From: Jeff Watson
Sent: Friday, May 24, 2013 12:42 PM
To: 'rg98926@yahoo.com'; Paul Jewell
Cc: Holly Duncan
Subject: FW: BL-13-00007 Grossman

[BL-13-00007 Grossman](#)

RECORD OF SURVEY

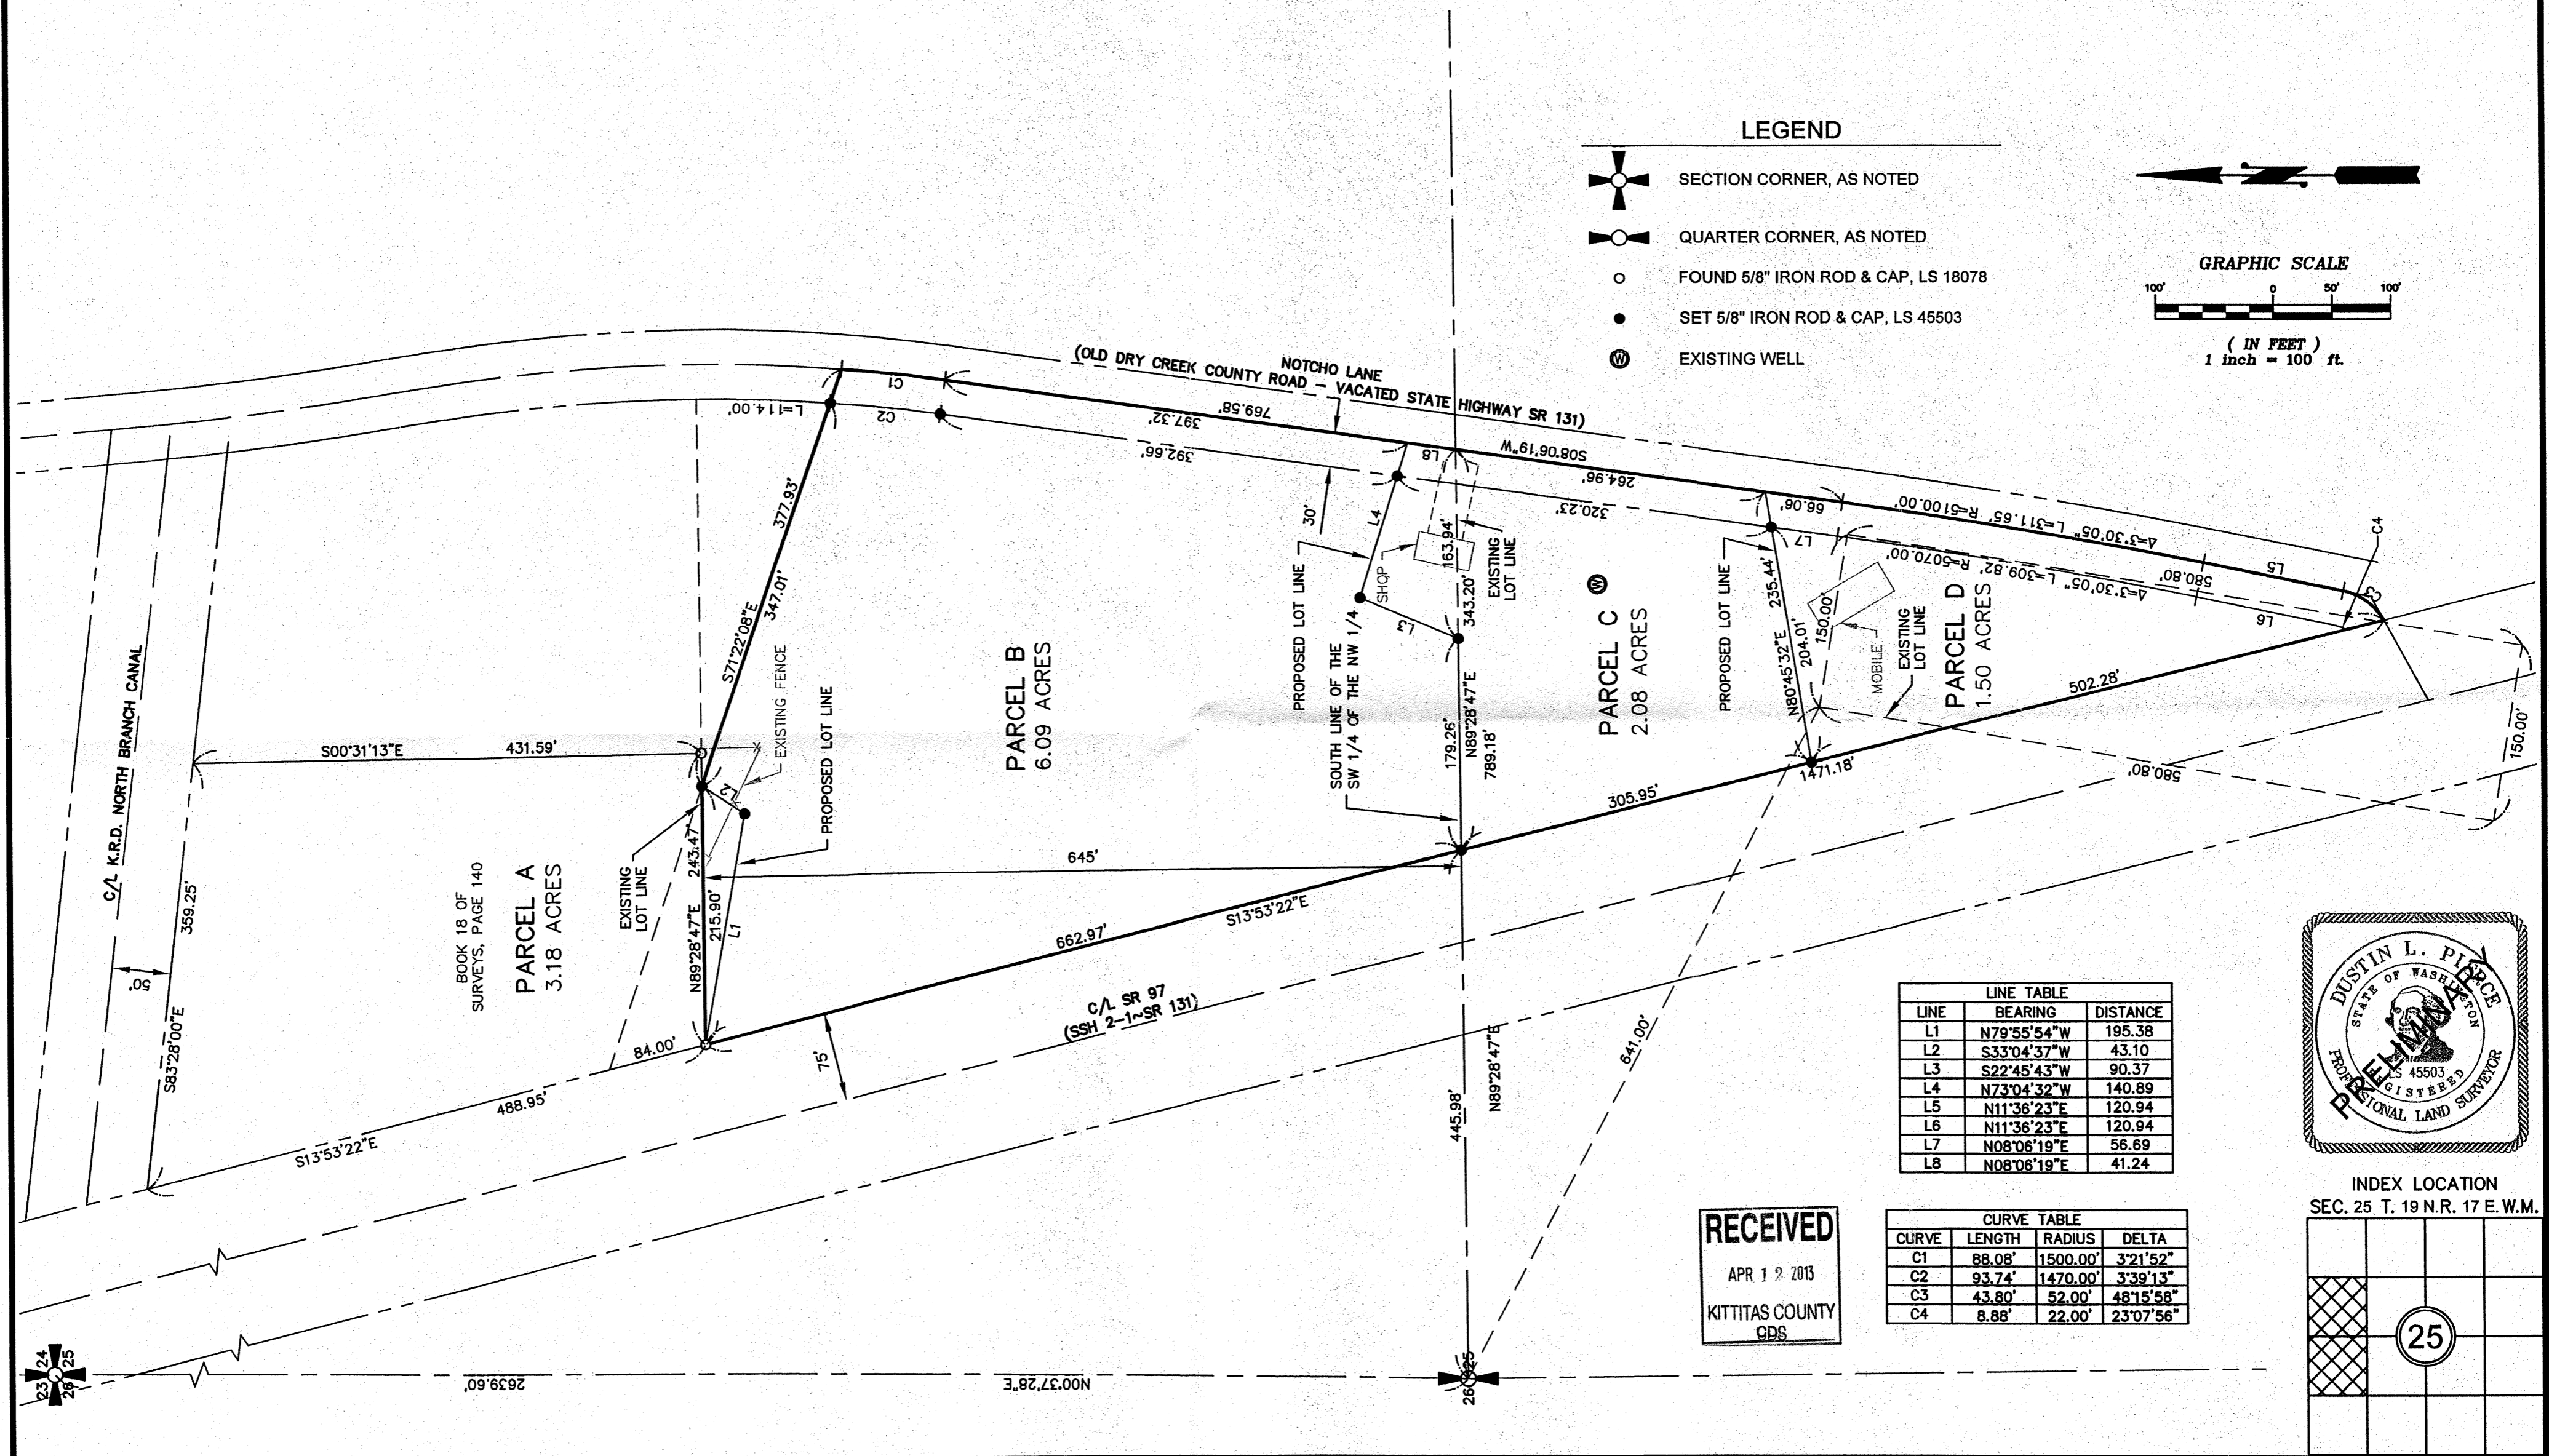
He needs to submit the recorded shared water user's agreement between parcels B and C. We also need a statement from Mr. Grossman saying that he has cut off the water supply to parcel D. Otherwise if parcel D stays on the well he technically has an illegal Group B water system that would have to be approved. Those two pieces of paperwork must be submitted before the BLA can be approved.

I just had a conversation with Rod Grossman. He said that the well on parcel C serves both parcels B and C and that based upon the conversation that he and I had a month or so ago he cut the water line leading to Parcel D. He says he will be selling that lot without water. Parcel D still has a mobile home on it. A recorded, shared water user's agreement between parcels B and C is required and a statement from Mr. Grossman saying that he has cut the water supply to parcel D and that he will be selling that parcel without water is also required. I will send you a copy of a shared water user's agreement that Mr. Grossman may use in another e-mail.

I was looking at this. I only see one well. How many houses are on that one well? Do you have that information?
